19/01705/OUT

Land Adjoining And West Of Bloxham Recreation Ground South Newington Road Bloxham.

Outline planning application for the erection of up to 95 dwellings with public open space, landscaping and sustainable drainage system (SuDS) and vehicular access point from South Newington Road. All matters reserved except for means of access.

Object to this application for the following reasons: -

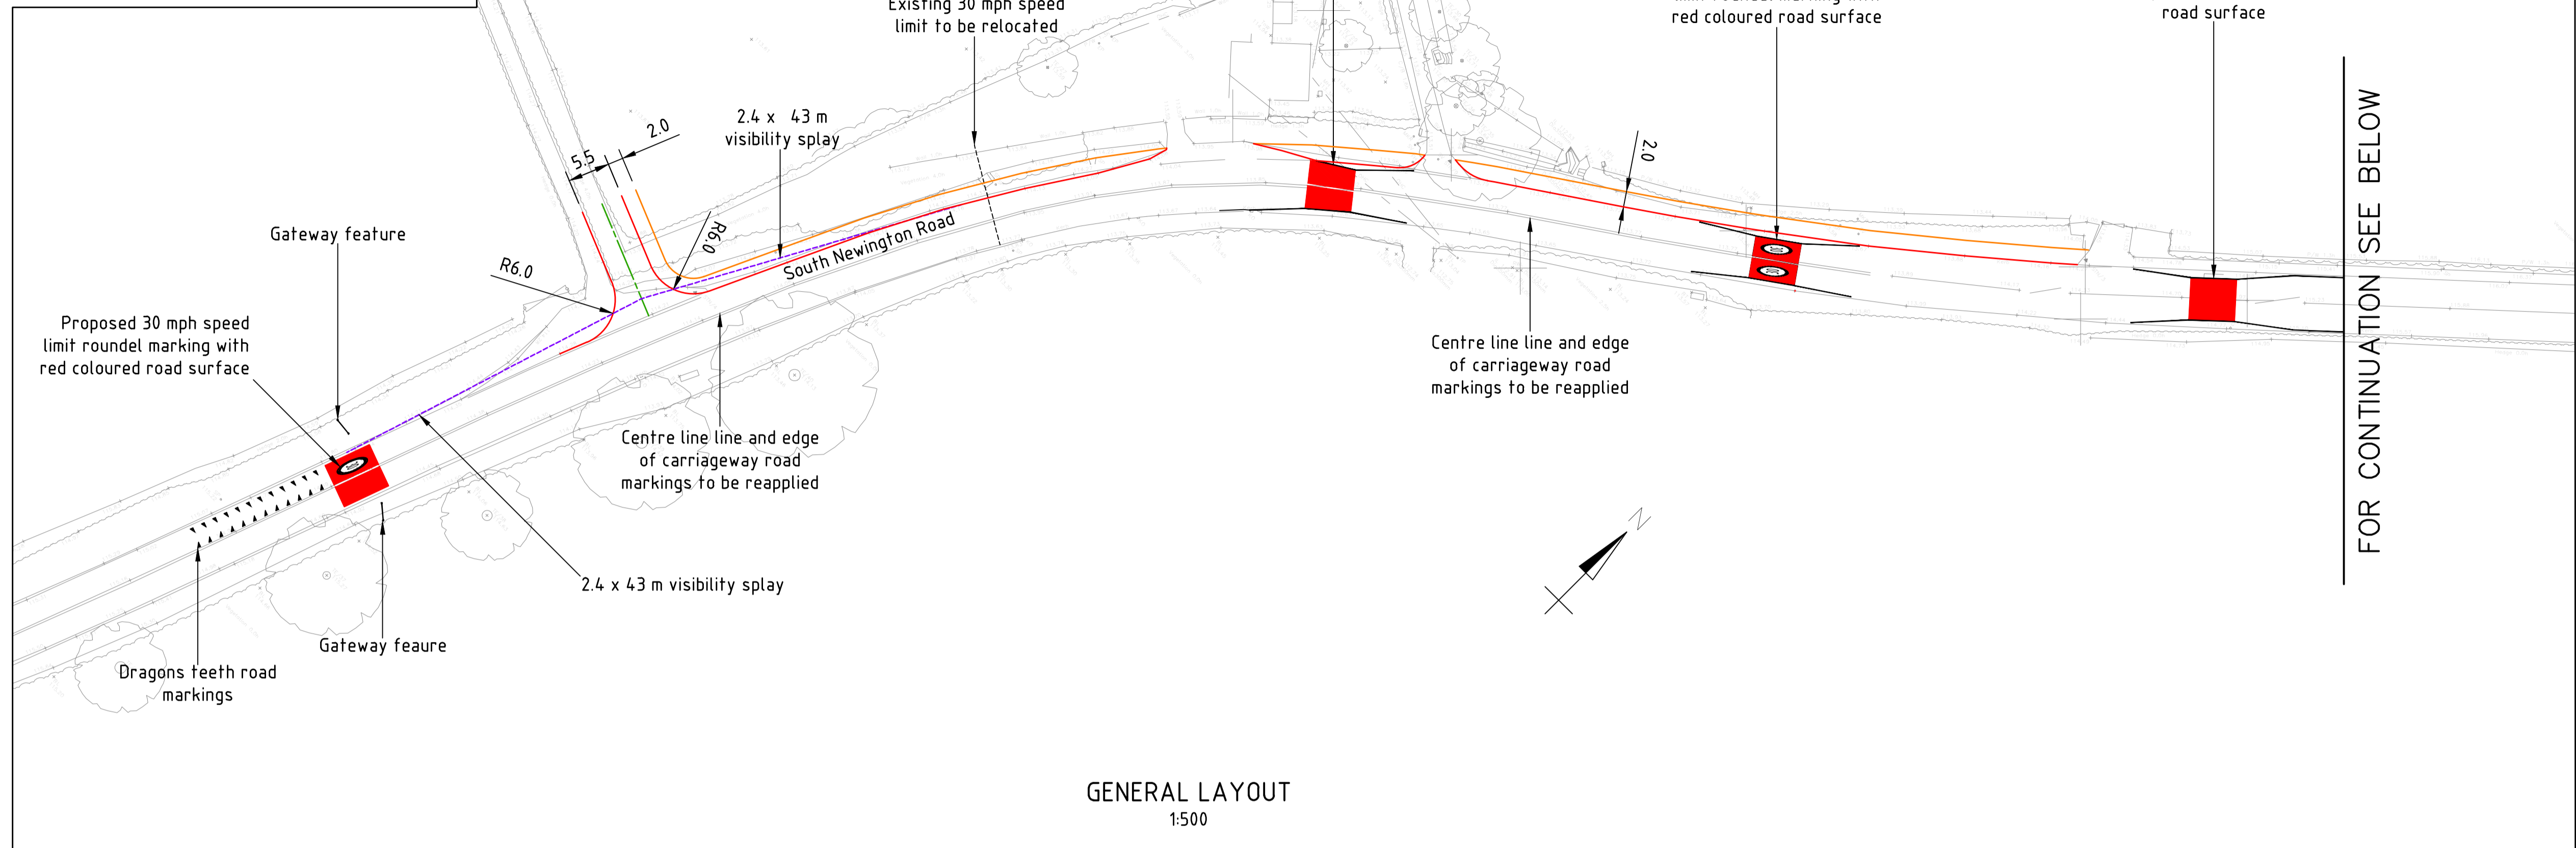
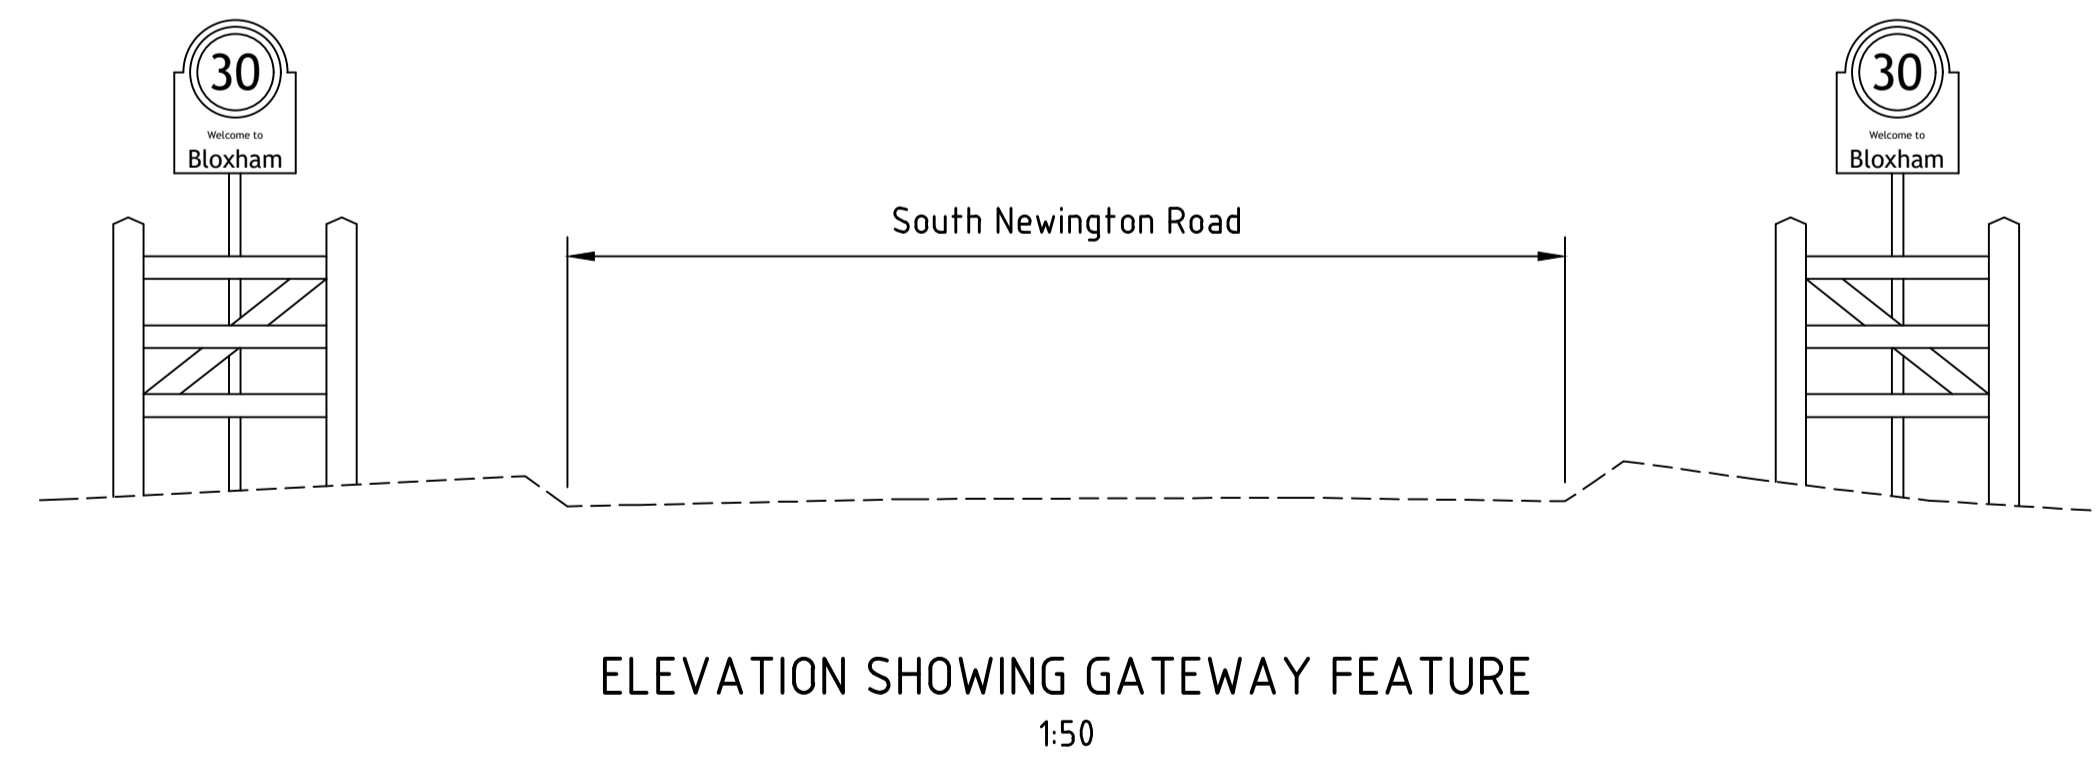
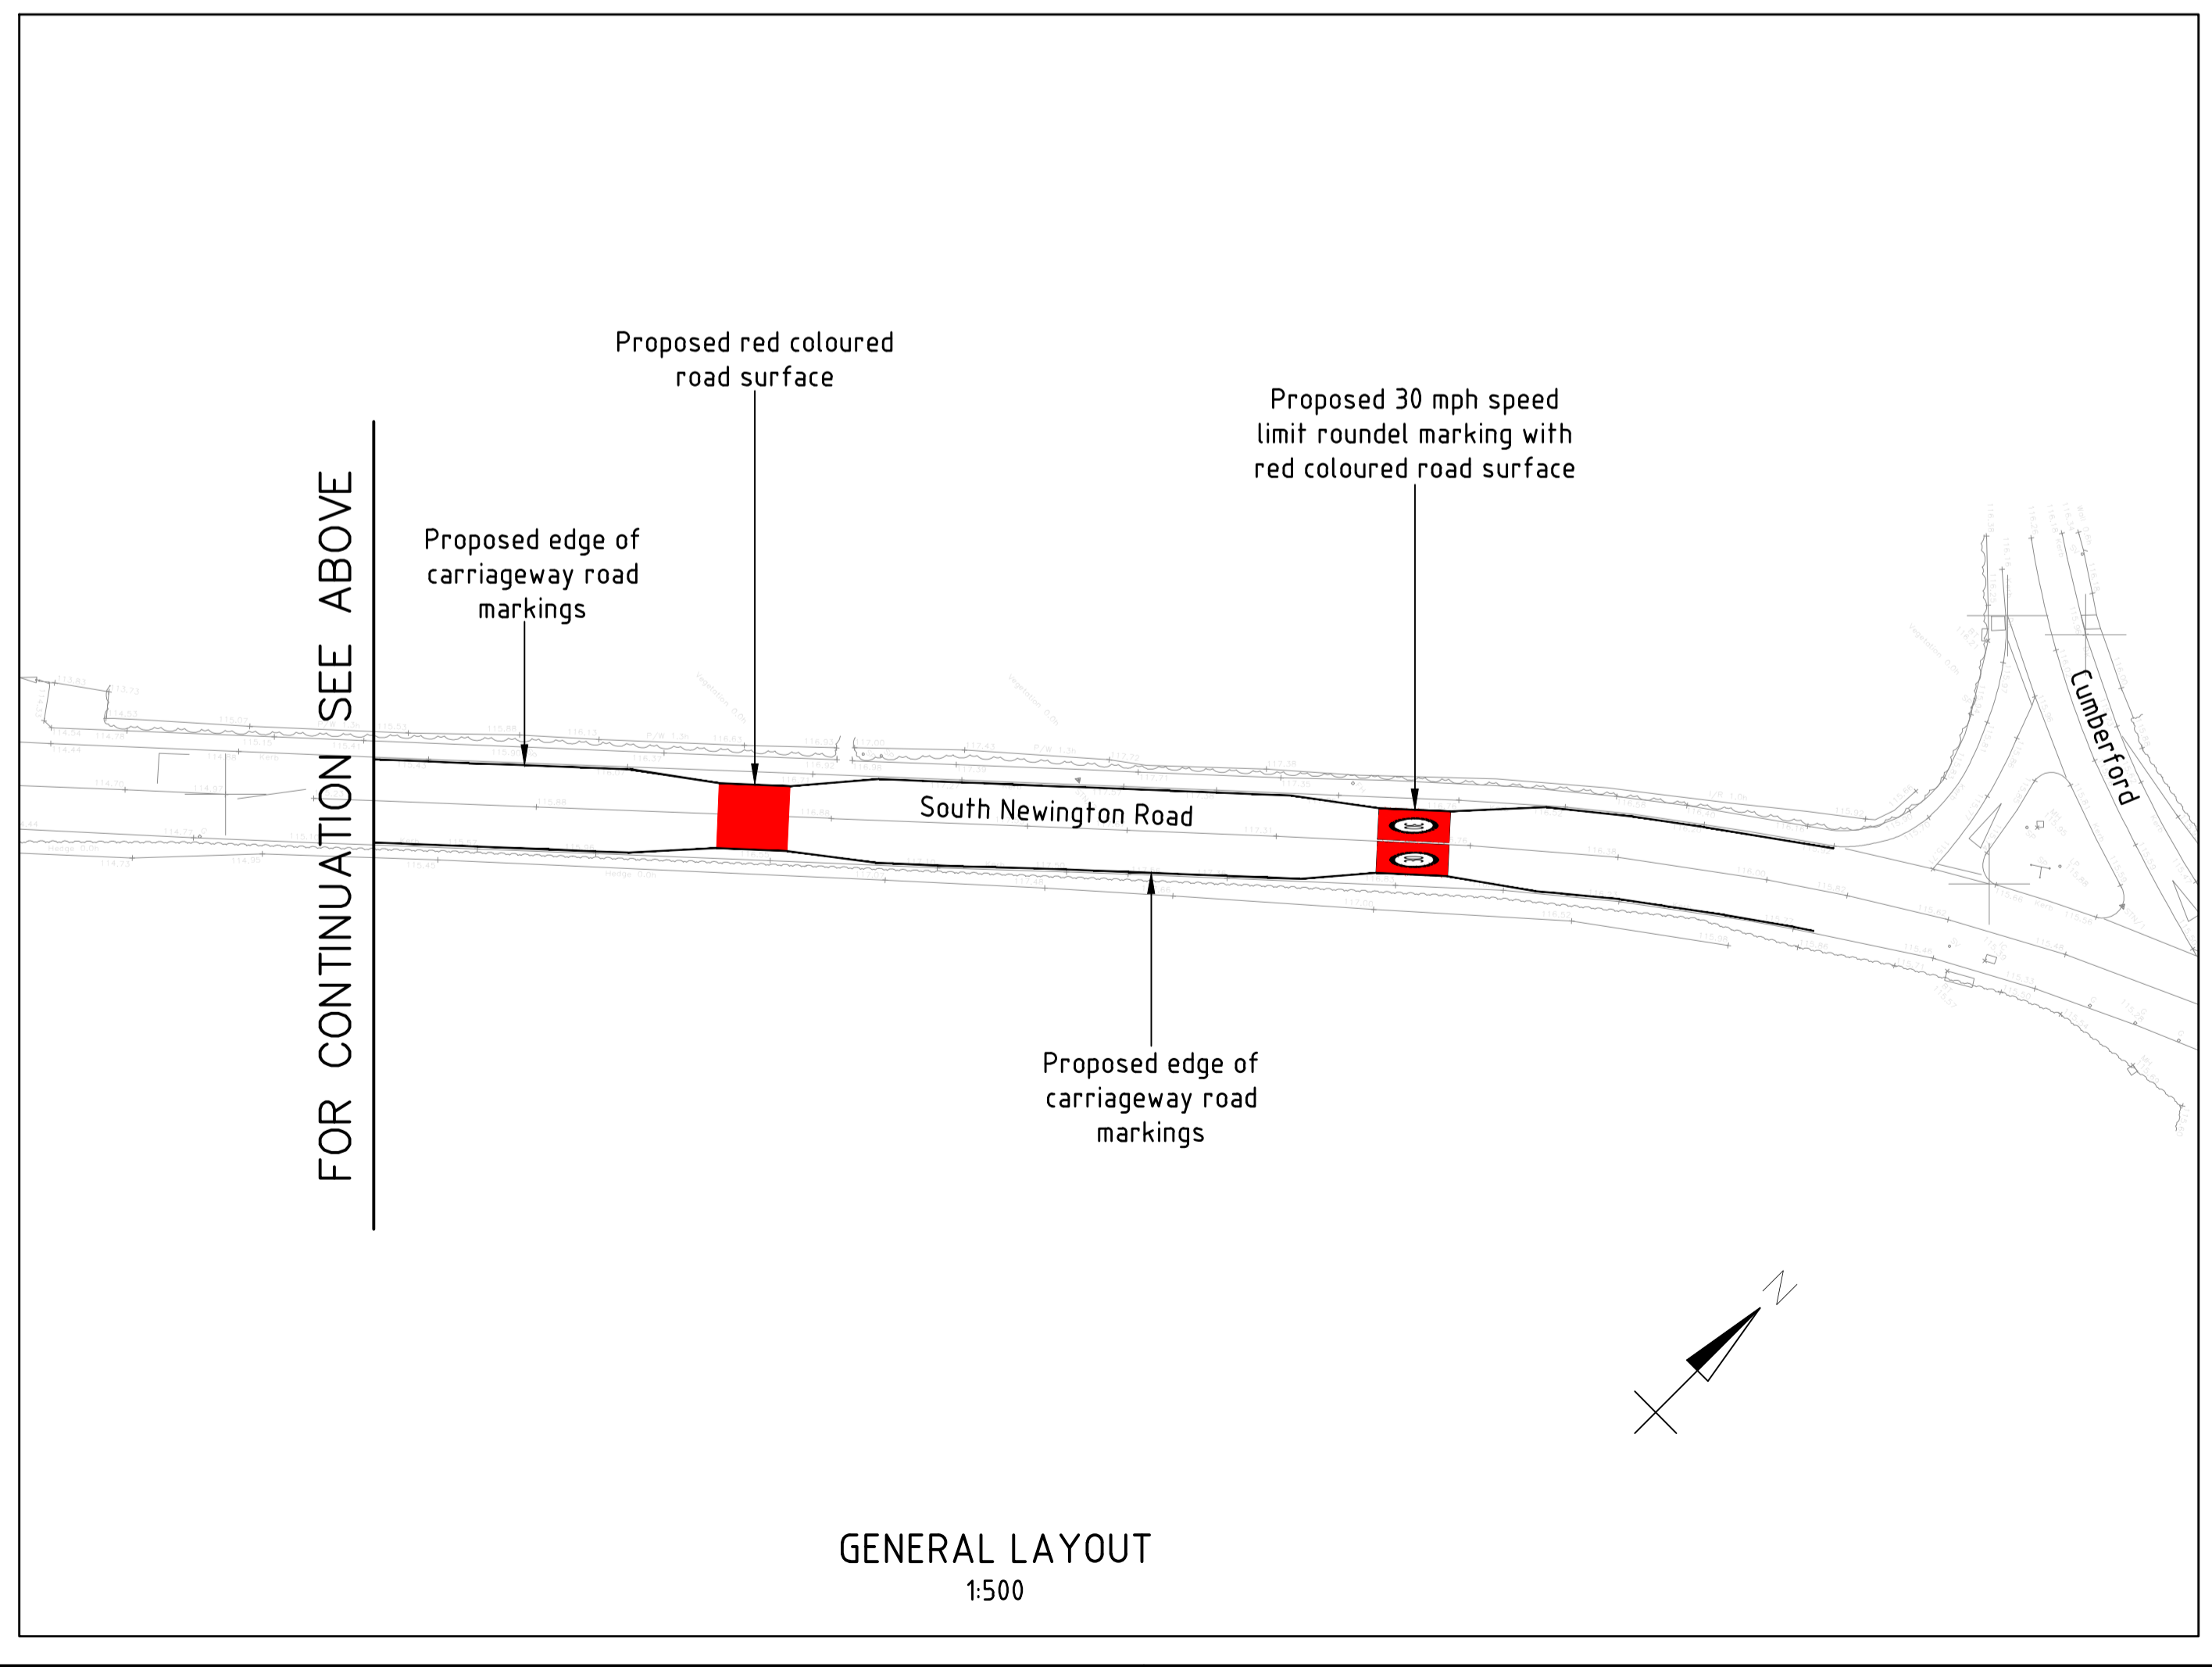
Preliminary junction layout & traffic calming measures Layout.

This layout provided by Stirling Maynard is dated January 2017.

Oxfordshire County Council has implemented safety works to the A361 in this area that does not appear to be taken into account.

At the very least before consideration is given to this application should a valid up to date lay out be provided for this critical matter?
